Additional comments to be incorporated to Neighbour representation id 1028498. As more information has come to light I would like to present additional and important comments relating to my previous objections to the proposed build at 18 Ullswater Close (application 2024/90137). I refer to The Design and Access Statement from Barnes Architectural Services under the heading 'Supporting Information' and specifically re: 2.0 SITE.

DRAWING TITLE
Proposed Elevations

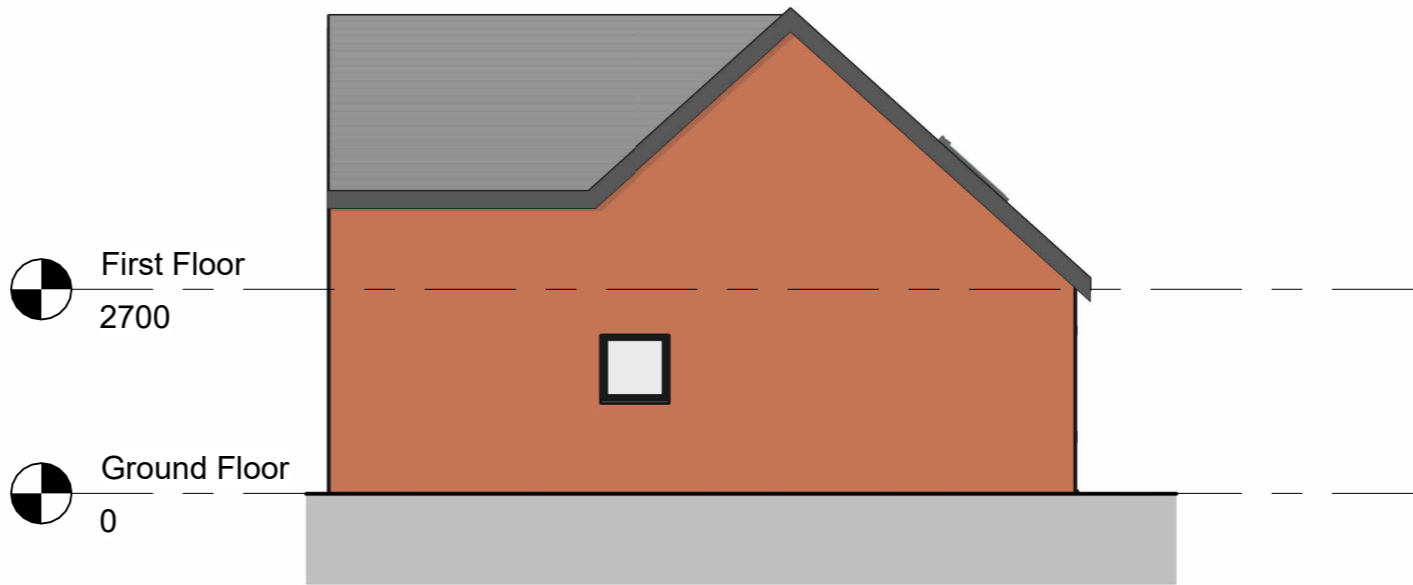
The scenario in Kennedy Close, whilst different in some ways to Welwyn road, is comparable as far as the gap between the side properties being much wider, and the driveway 'fans out' to give good access. The property is not hidden away but appears prominent and accessible to any appropriate emergency vehicles. Both these properties appear to be low profile dormer type buildings unlike the proposed dwelling at 18 Ullswater Close where, in particular the rear aspect of the build has a two storey dormer with large 'picture windows at the apex clearly overlooking gardens and bedroom windows on Ullswater Avenue.

Proposed Site Plan

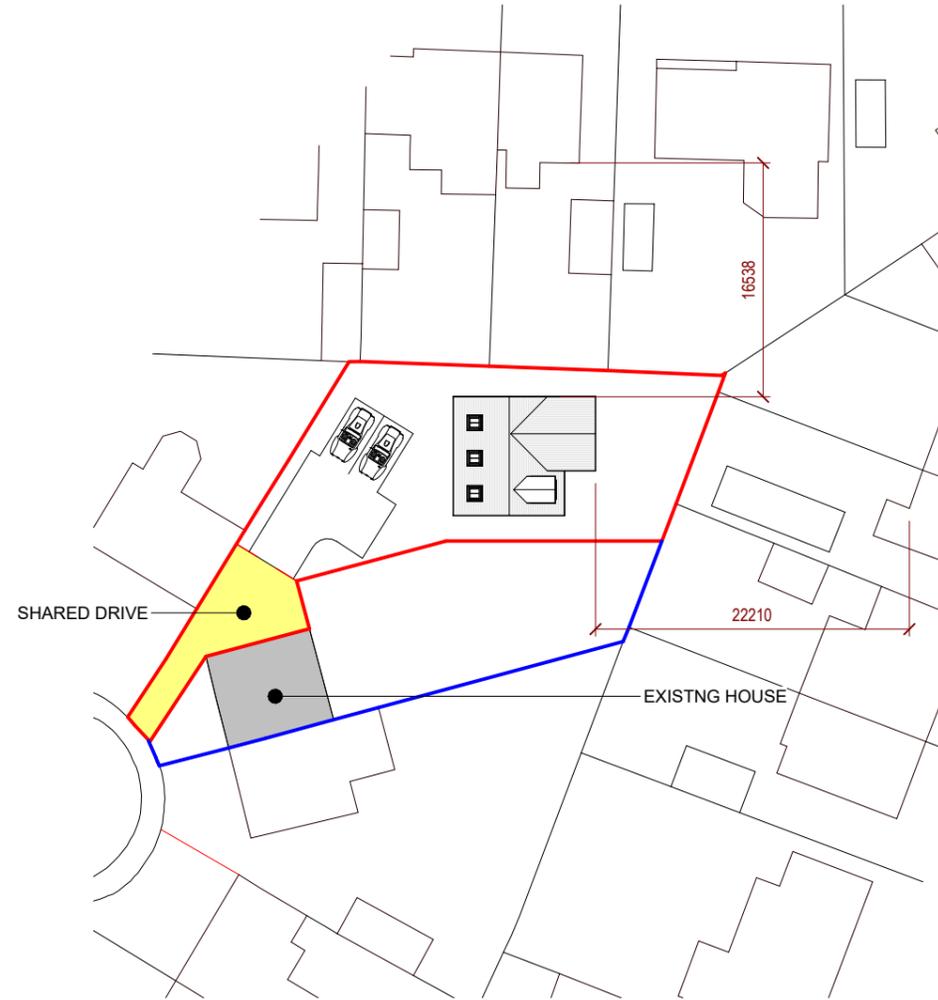
Regarding the vehicular turning provisions to the proposed build, again under the heading of 'Supporting information', this completely misses the point - Potentially two three bedroomed houses occupying around 10 occupants could generate the use of 5 cars which would be passing a side door on to a very narrow driveway creating a hazardous and dangerous scenario. The comment saying 'there will be no reversing on the driveway again misses the point as it is the small confines of the driveway adjacent to an opening door that would create the danger regardless of reversing or not.
